RE: Major Projects – SEARs Request – Leppington Civic Centre at 173-183 Rickard Road, Leppington (SSD-99319962)

Below is a summary of the points discussed at the meeting and additional comments that form Camden Council's response to the request for SEARs:

BYRON ROAD - TYPICAL CROSS SECTION
(CH 75.00 - CH 195.00)
SCALE 1:50

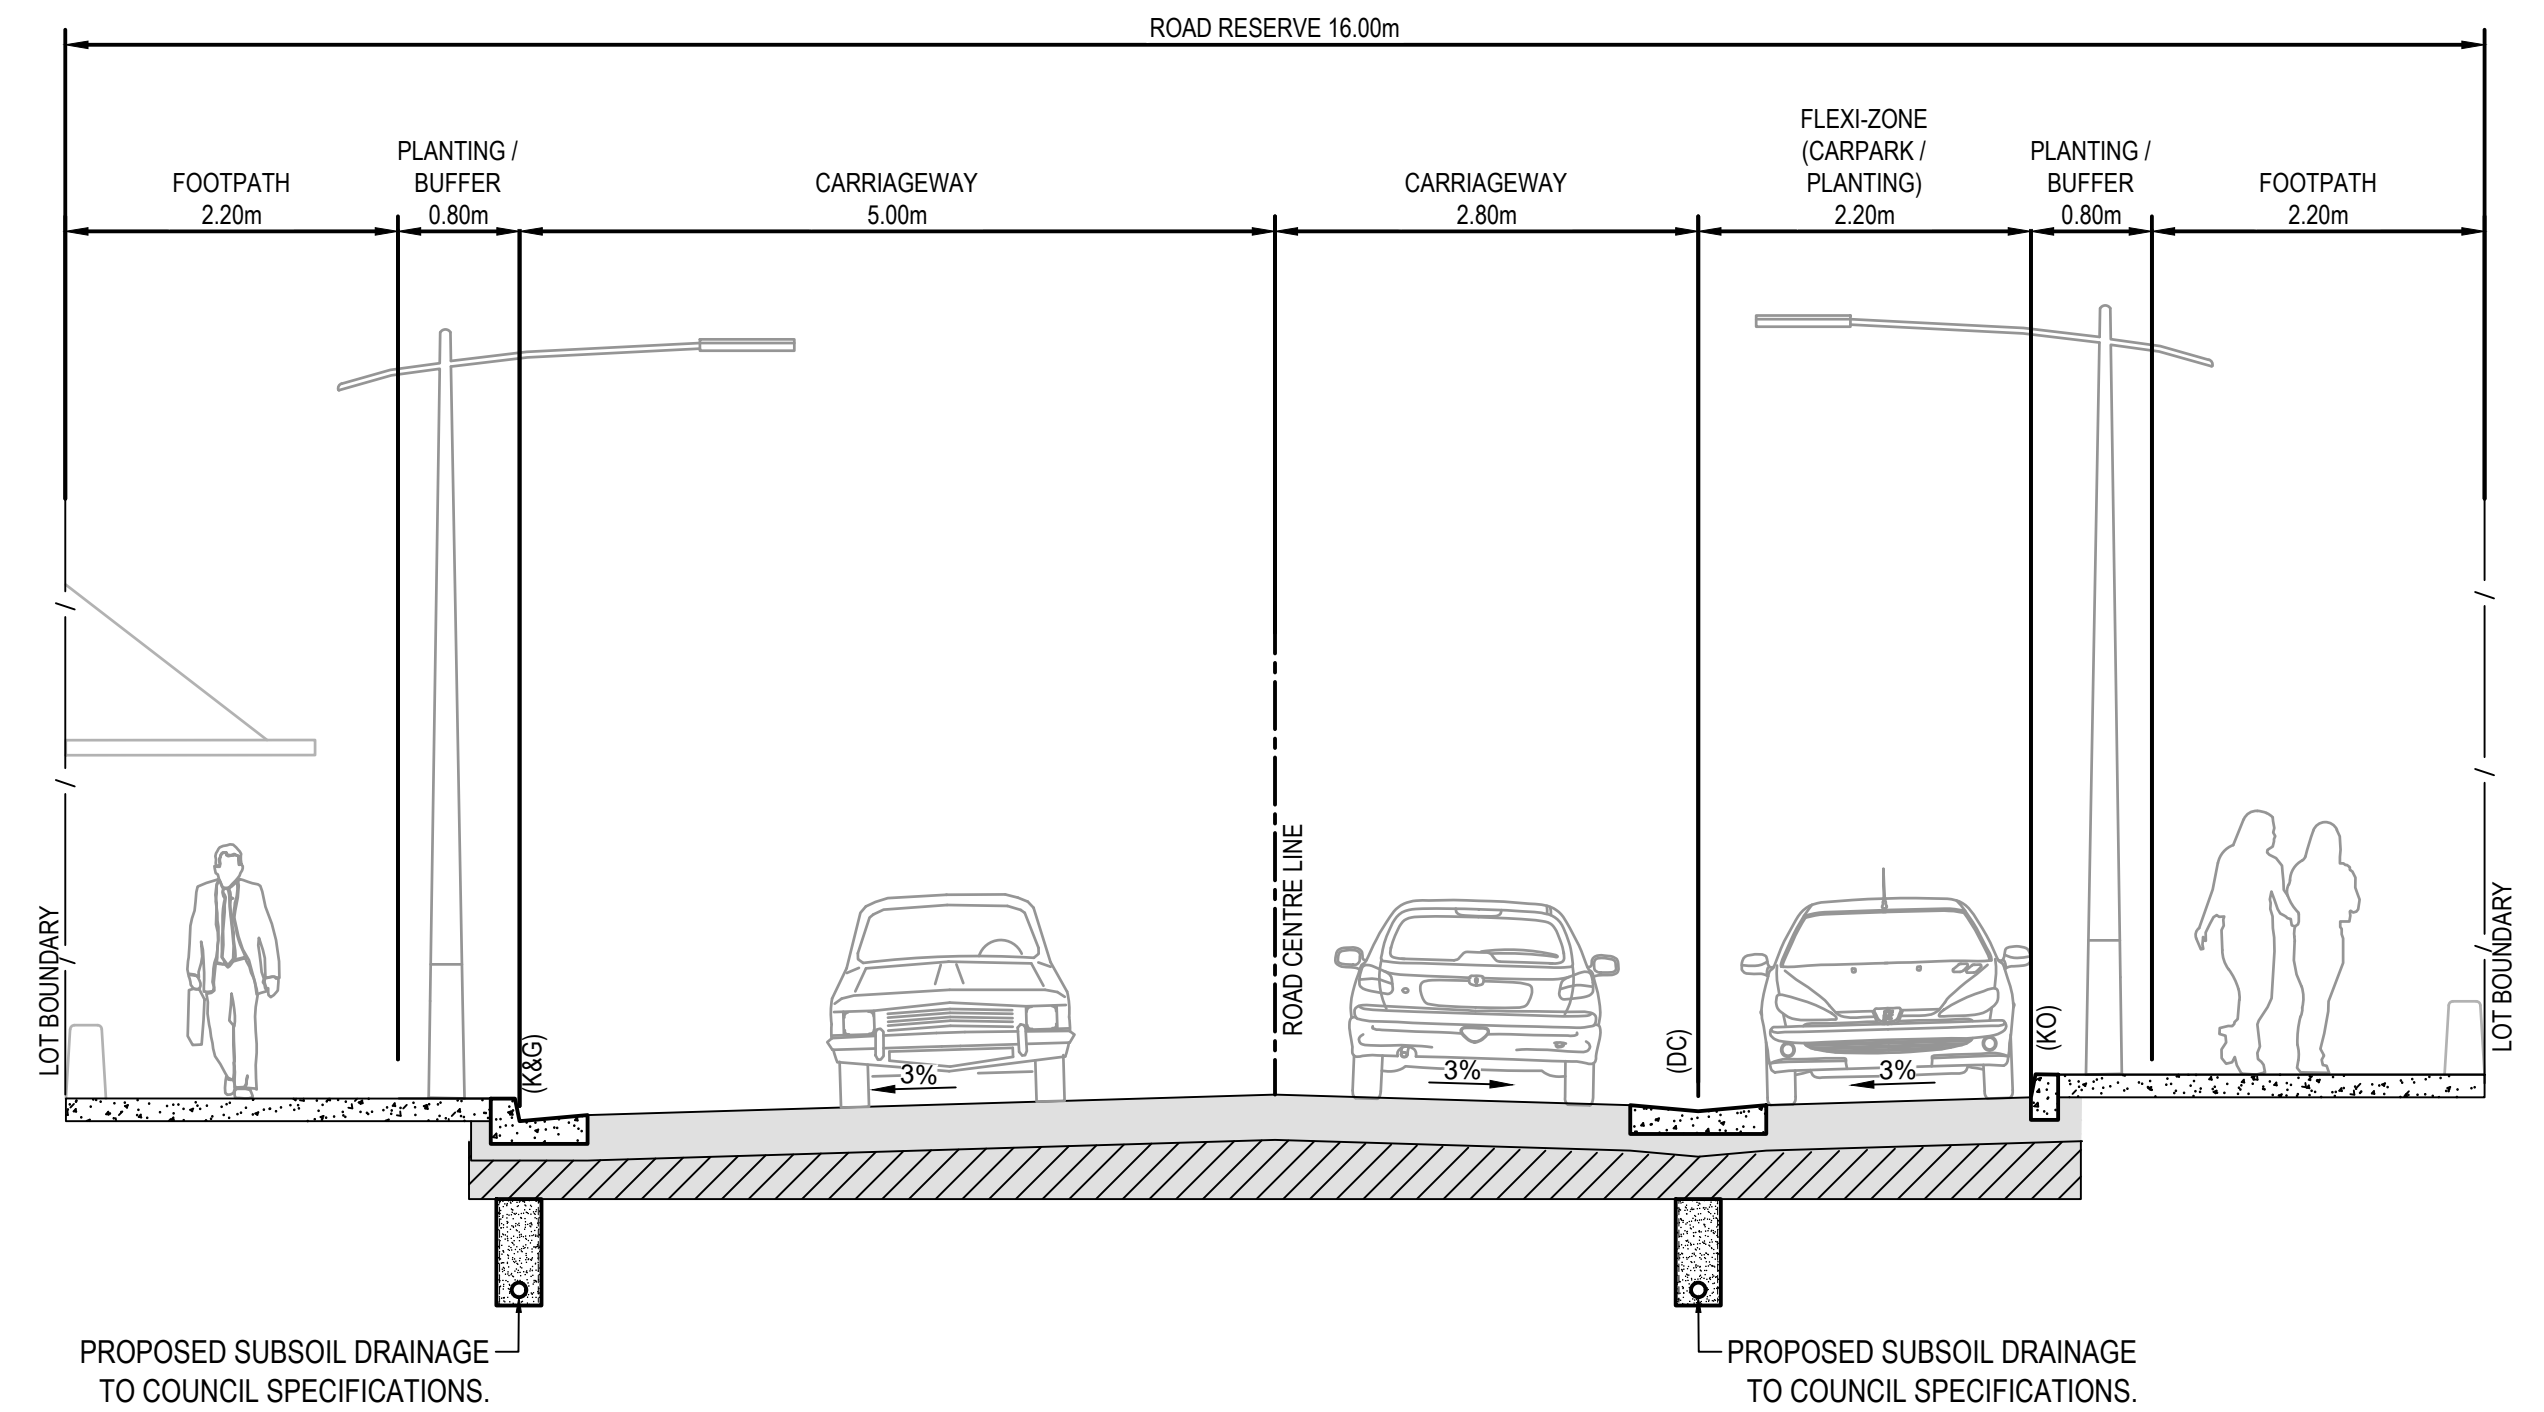
- TfNSW also raised concern with the conflict that the proposed extension of Byron Road (west of Rickard Road) would have on the existing driveway entrance to the commuter car park.

- This outcome is/was less than desirable and the completion of all public domain works, including the extension of Byron Road (west of Rickard Road), should be completed as part of any proposed development.

- The applicant should consult with TfNSW (early and ongoing) to ensure the Byron Road (west) extension is completed and access to the commuter car park is provided from this new road.

- The road geometry of the Byron Road extension (west of Rickard Road) should also align with the site specific provisions ultimately established in the finalised LTC SARP (to ensure bus access is available to the bus interchange).
